Re: Administrative Amendment (AA) request #1002092/10AA-10009

I have reviewed the request you submitted for an Administrative Amendment (AA) for a retaining wall on Lot 35A of Oxbow Bluff. The application is incomplete at this time. Please submit the following items:

Re: Lot 35A - Oxbow Bluff; Review of the Lot Specific Grading and Drainage

**Re: Lot 35A Oxbow Bluff, 5008 Grey Hawk Ct NW, Grading and Drainage Plan
Engineer's Stamp date 1-28-10 (G11/D014D)**

LOT 35A OXBOW GRADING AND DRAINAGE PLAN	DRAWN BY WCKJ DATE 9-16-09 2031-LAYOUT-9-16-09
	Rio Grande Engineering 1606 CENTRAL AVENUE SUITE 201 ALBUQUERQUE, NM 87106 (505) 872-0999	SHEET # JOB # 2931
DAVID SOULE P.E. #14522

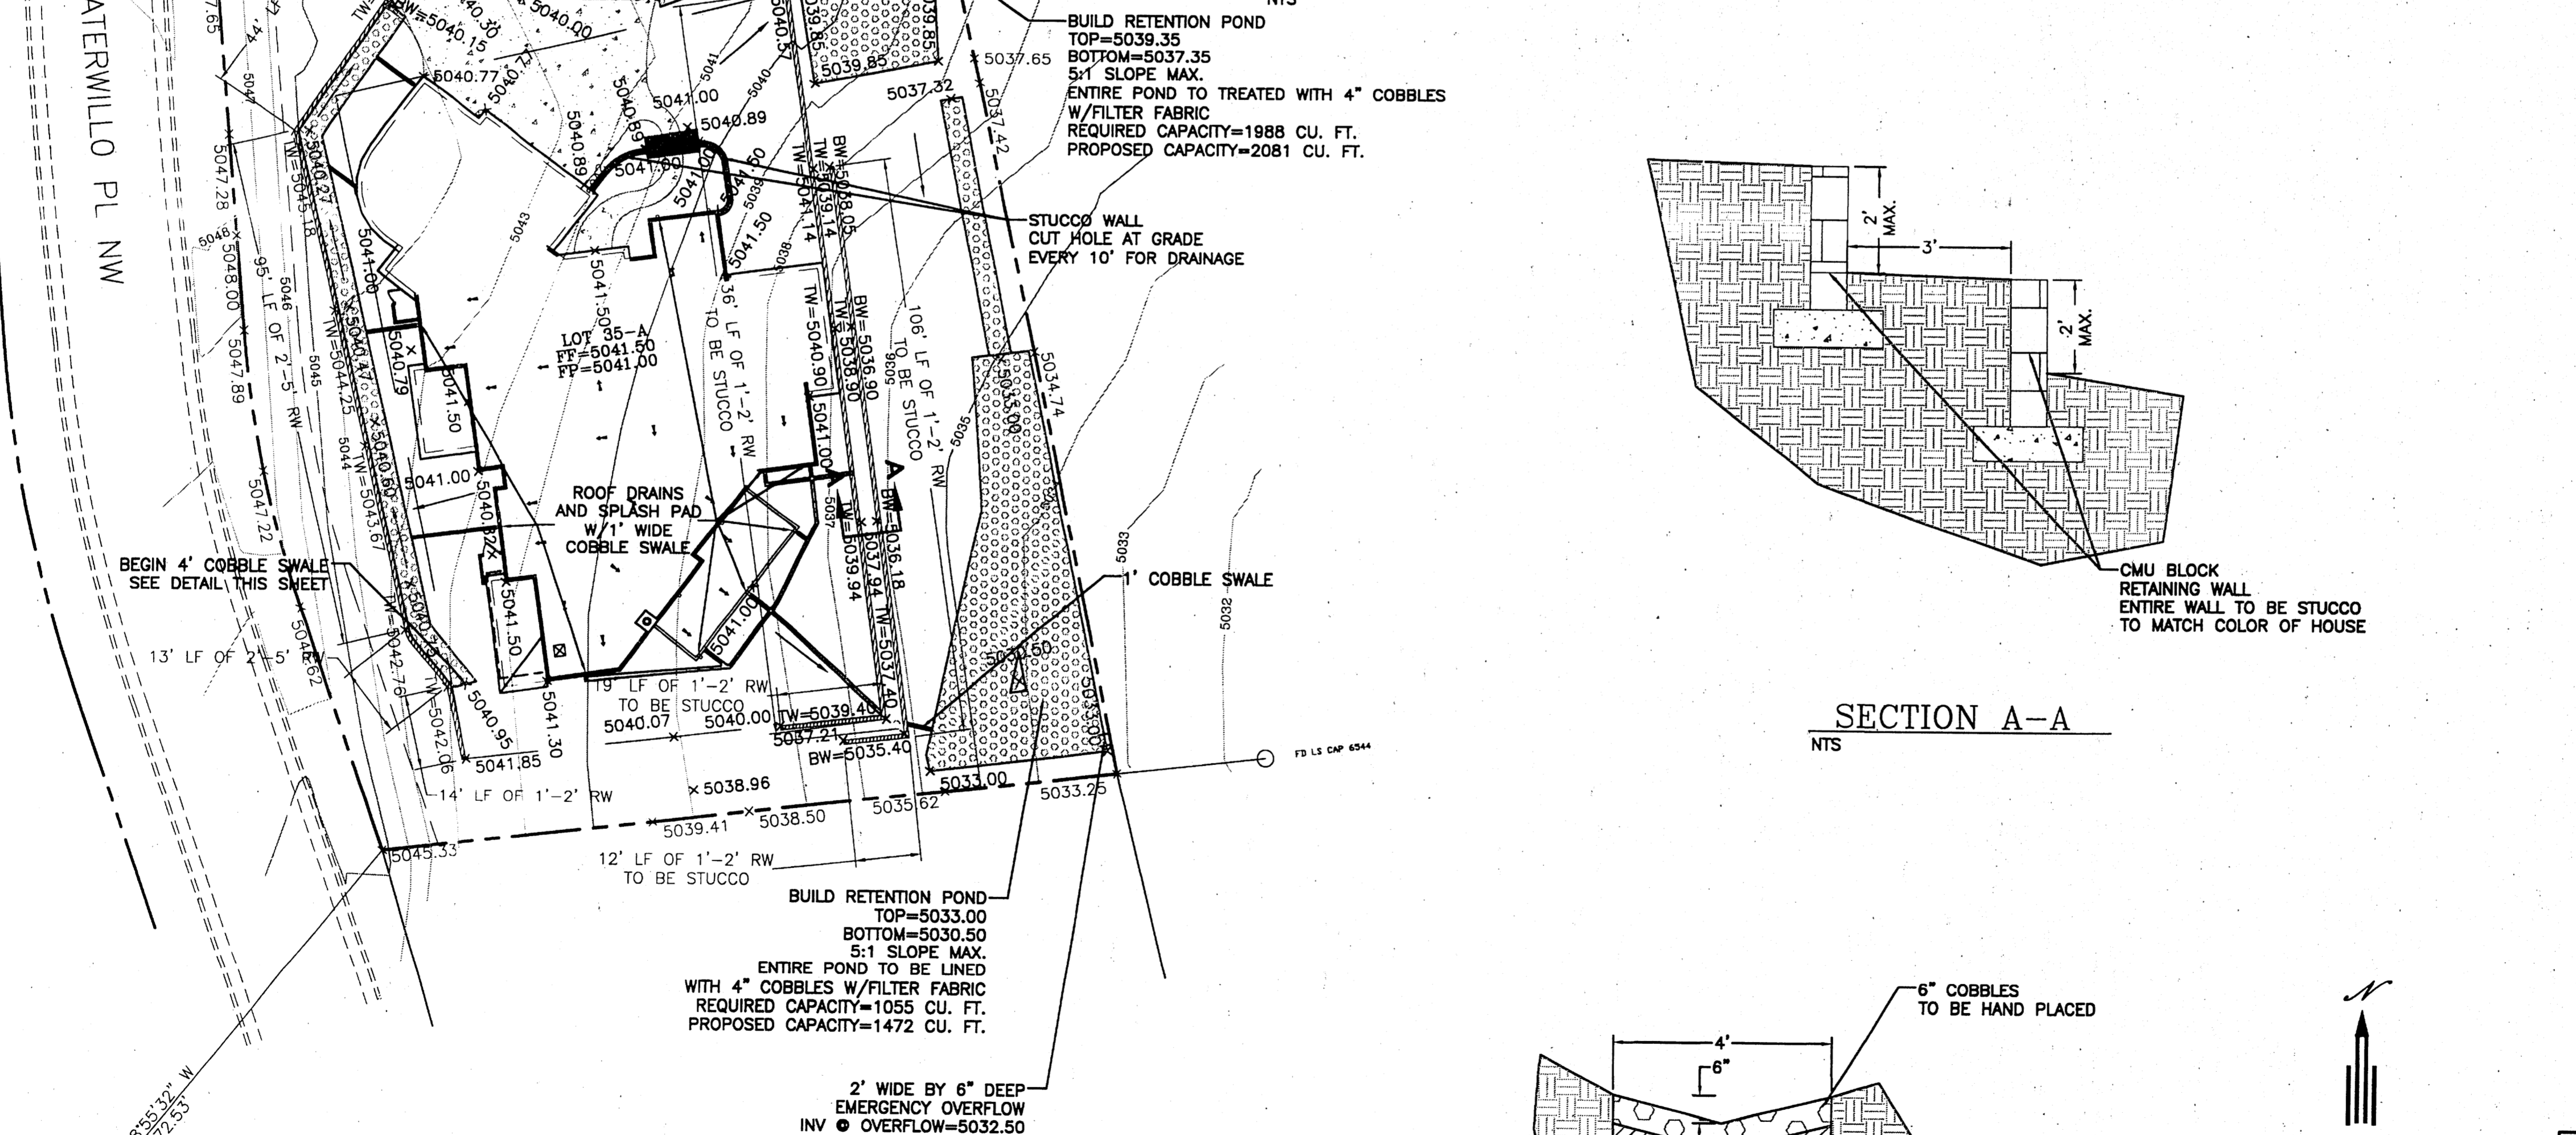
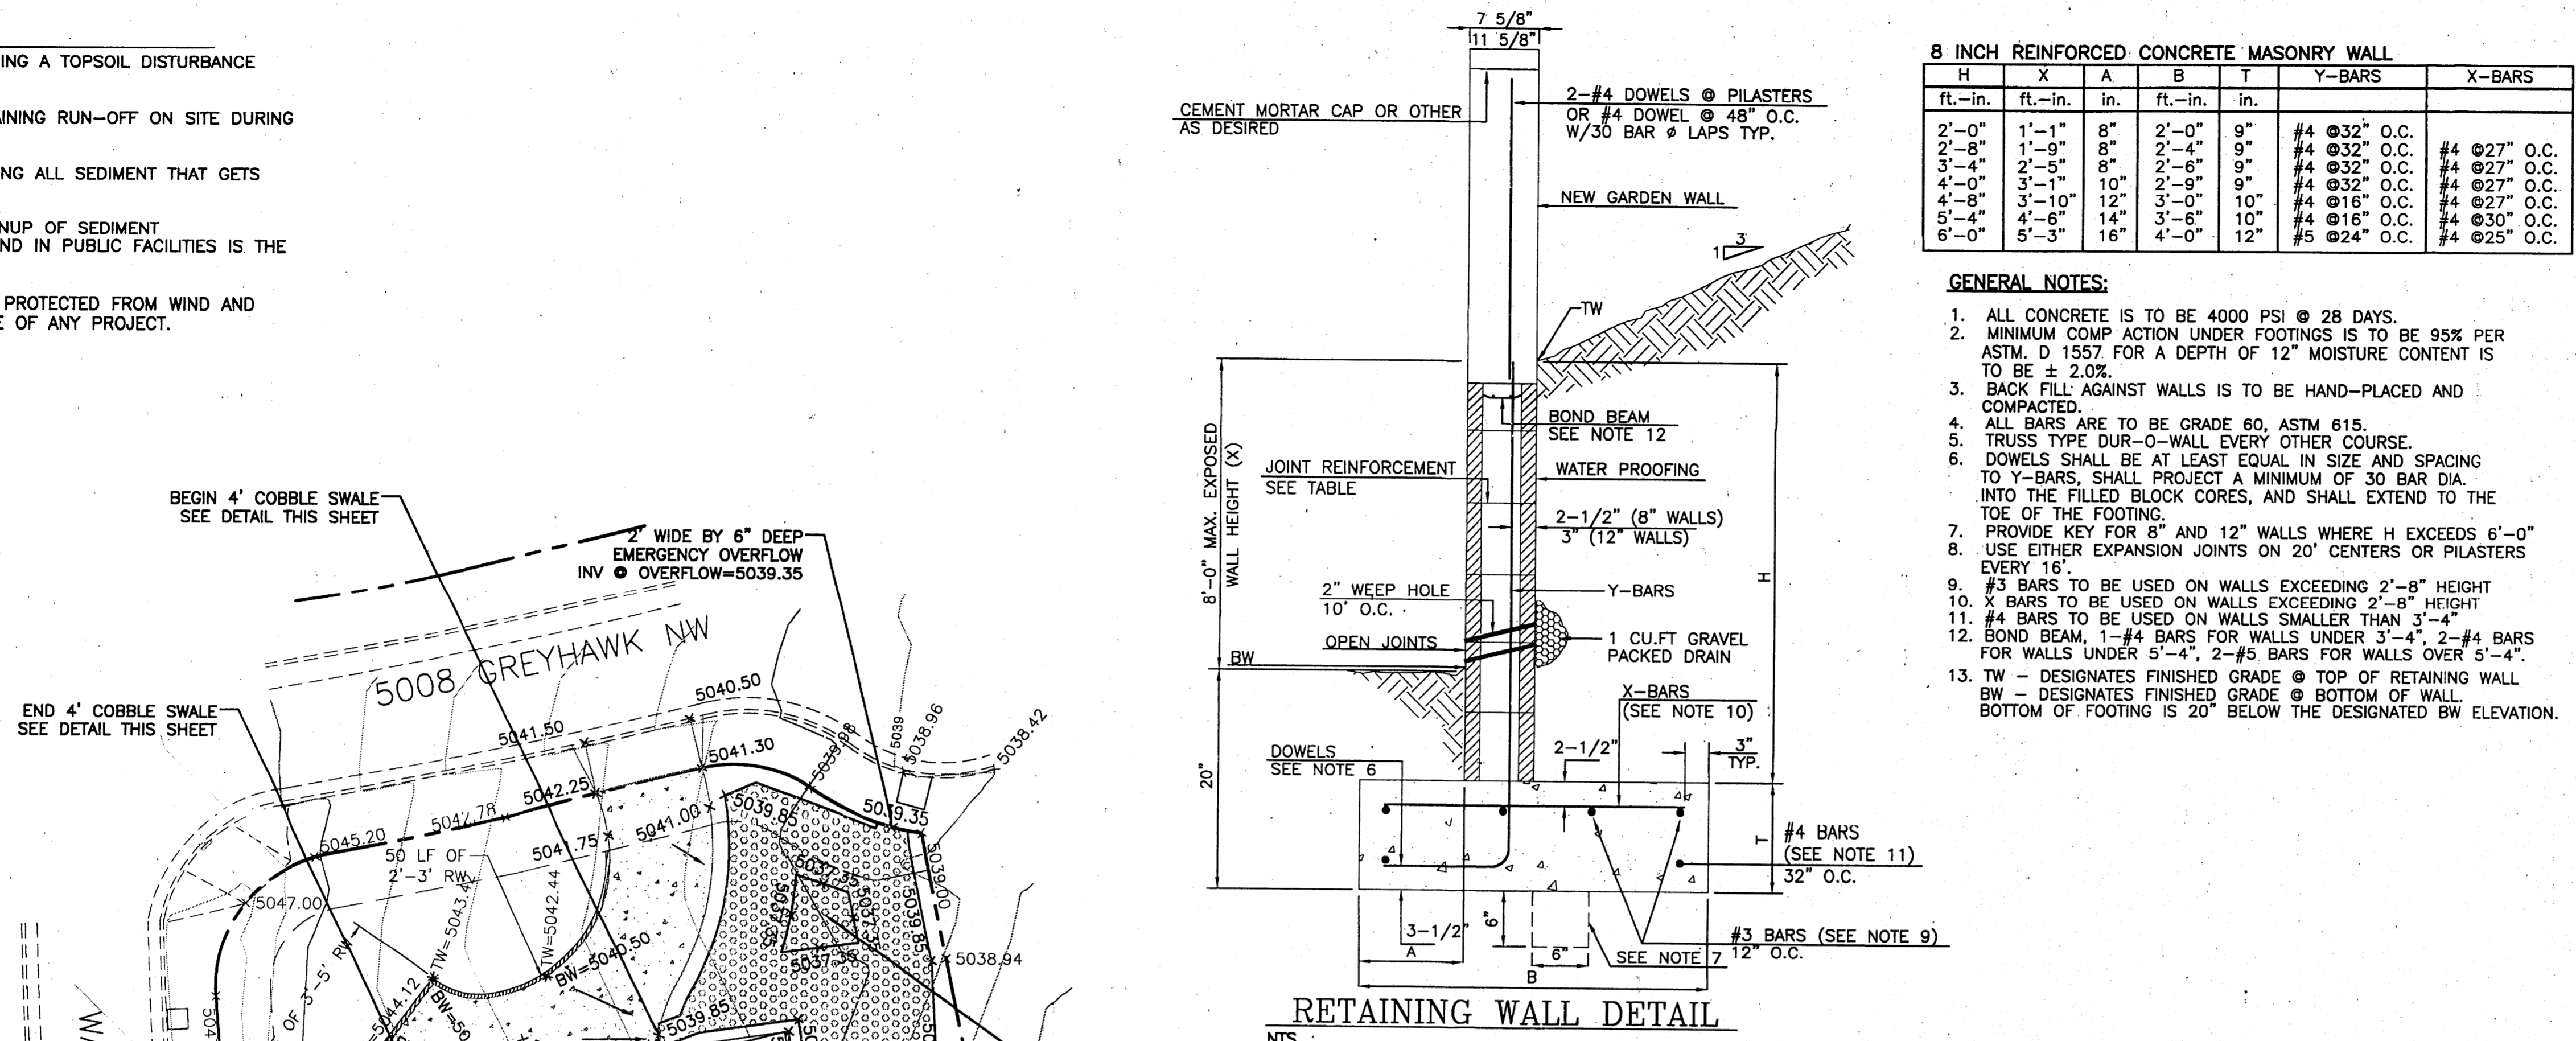
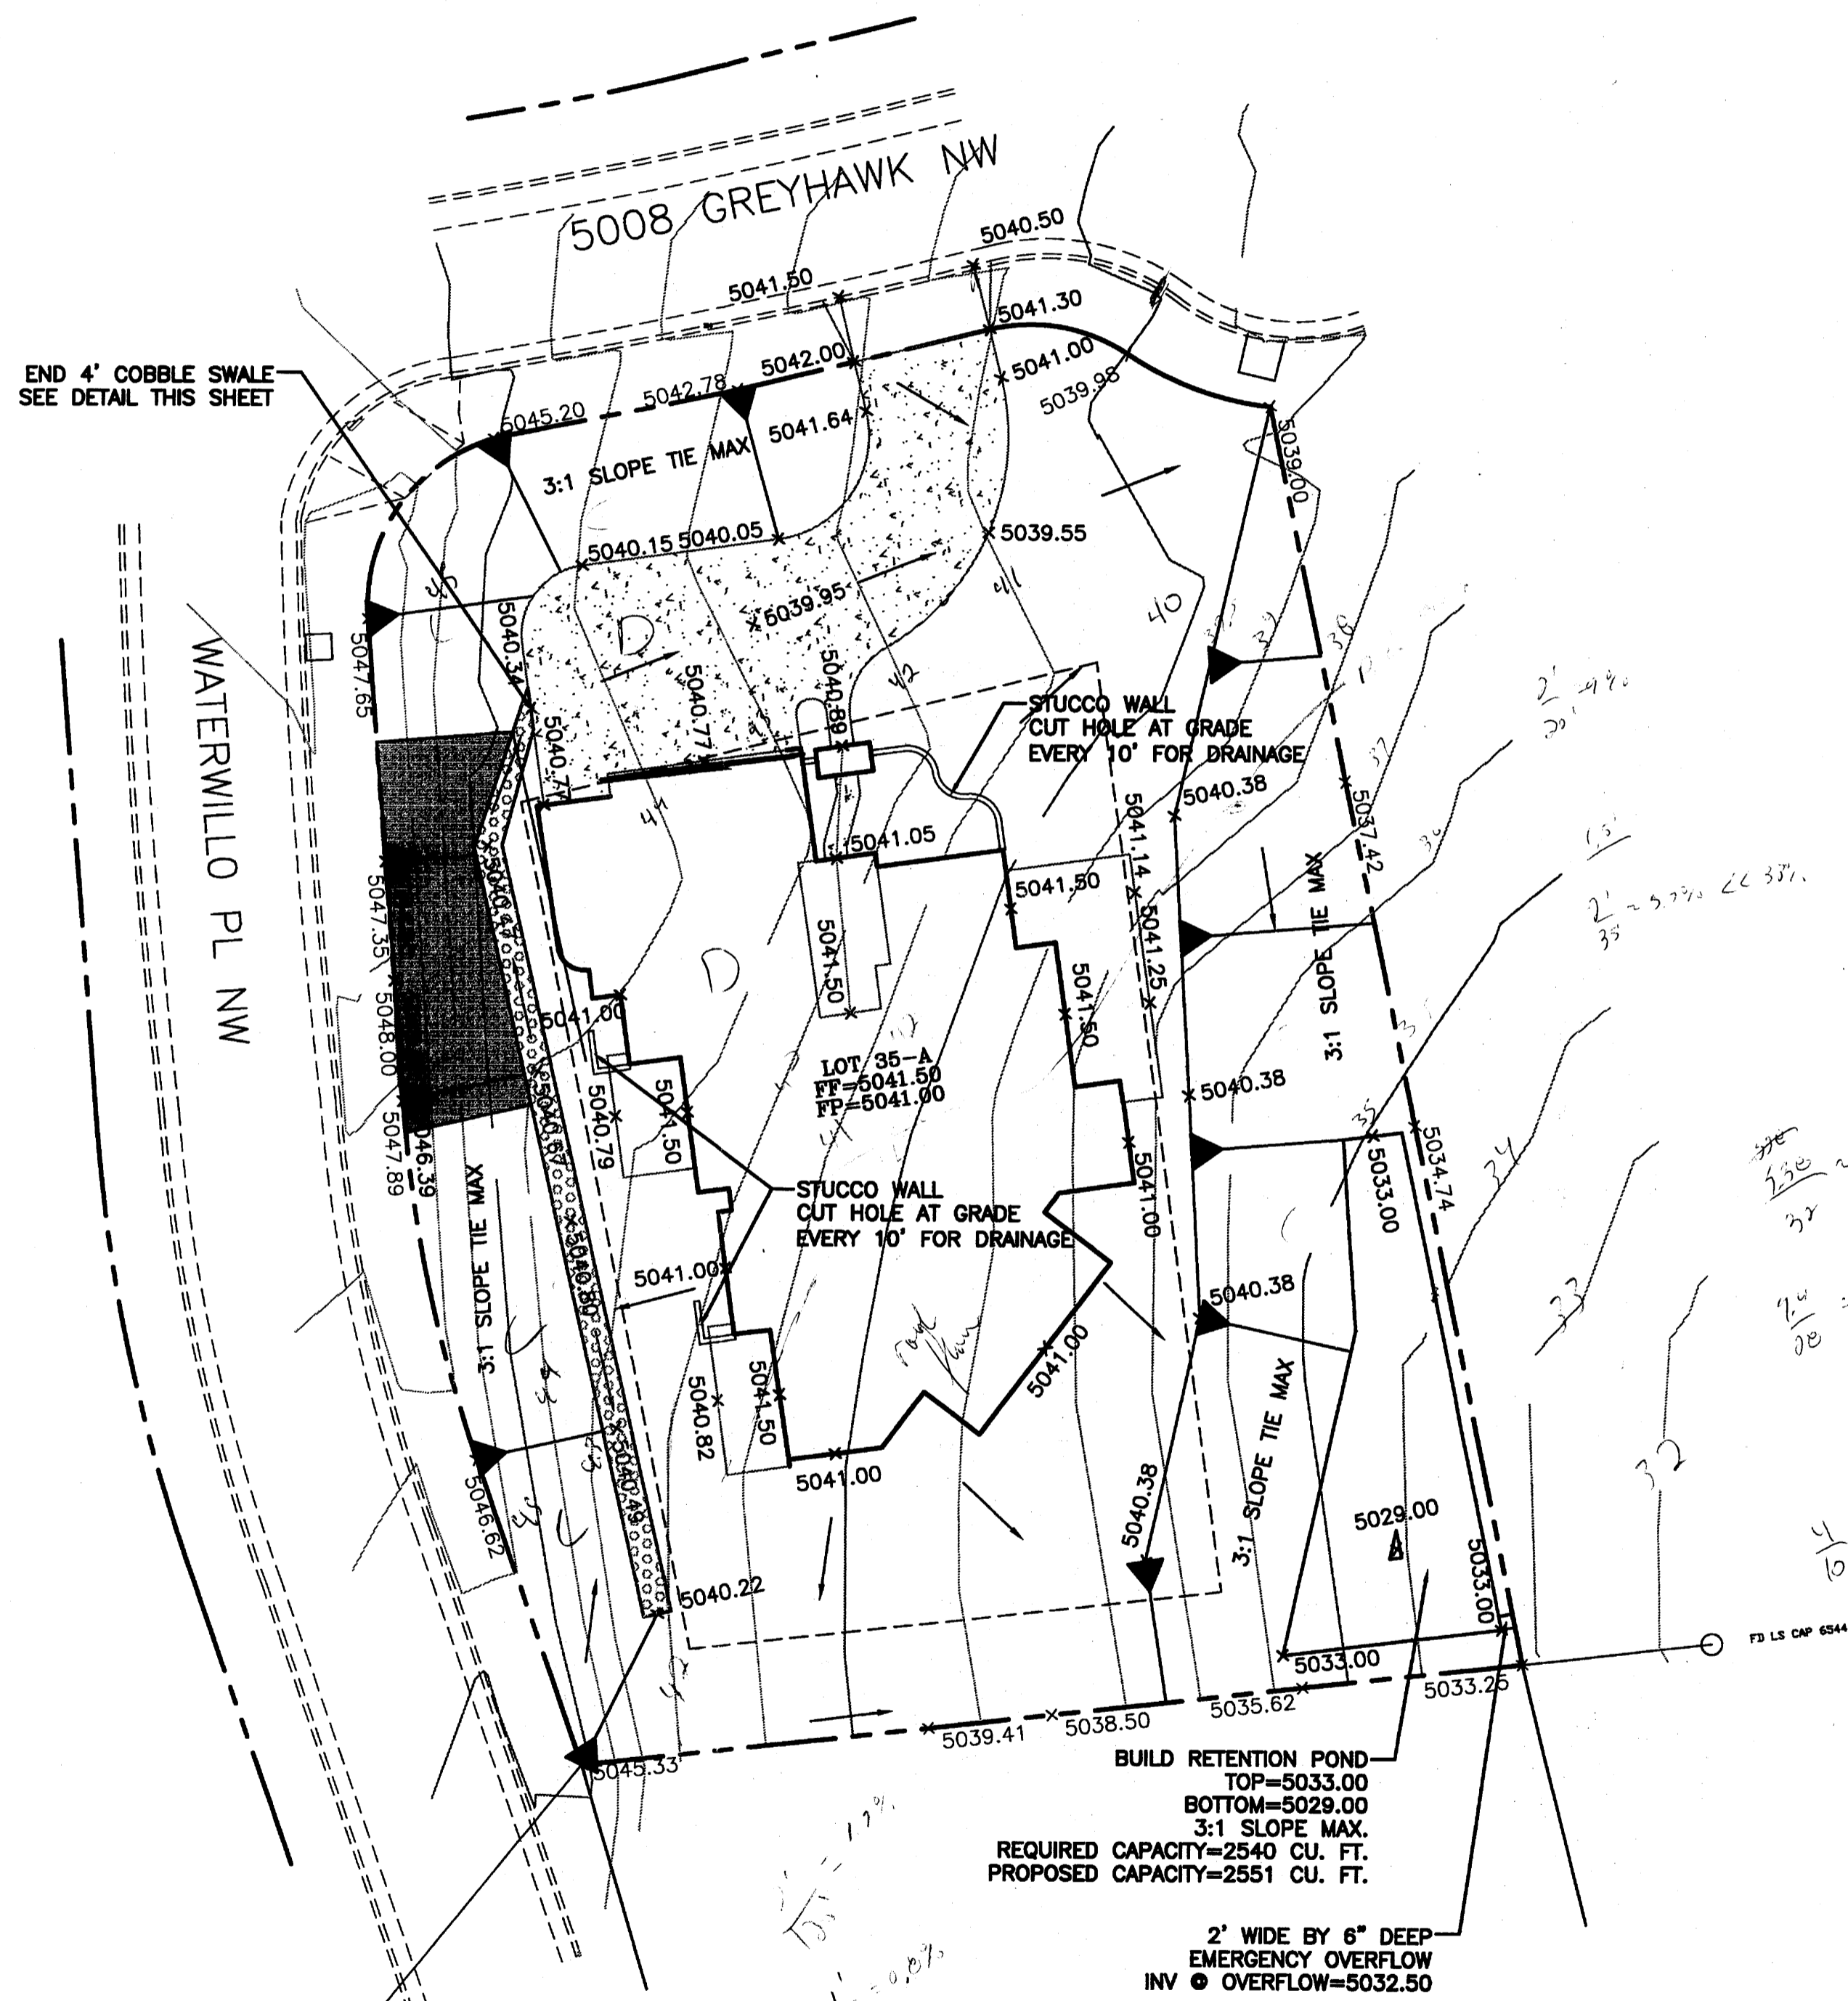
- A little more of the site should drain to Grey Hawk Dr. The basin divide should be approximately from the south west corner to the north east corner. Provide basins and direction of roof flows on the plan.
- It appears from the Grading Plan for Oxbow Bluff Subdivision-Tract F dated 10-17-97 this lot is in Basin F. The Drainage Report specifies 39% impervious and 61% natural areas for Basin F.
- Slopes that are graded 3:1 will become Land Treatment C. It appears the approximate land treatment percentages on the plan provided are: A-10%, B-10%, C-45%, and D-35%. Update calculations.
- If the pond overflow is dirt, how will it remain at 32.50? Some wind and water erosion should be assumed. In addition, it appears the 33 contour is downstream of the spillway at 32.50.

we don't have this
plan stamped
1-28-10.

plan submitted is
stamped 1-4-09
and plan rev by
Hydroel is stamped
9-18-09

① ~~2533~~ ~~enbridge~~ - not
shown on plan
2557

① letter says 2533 ~~ft~~3
req - plan says 2540 ~~ft~~3
req
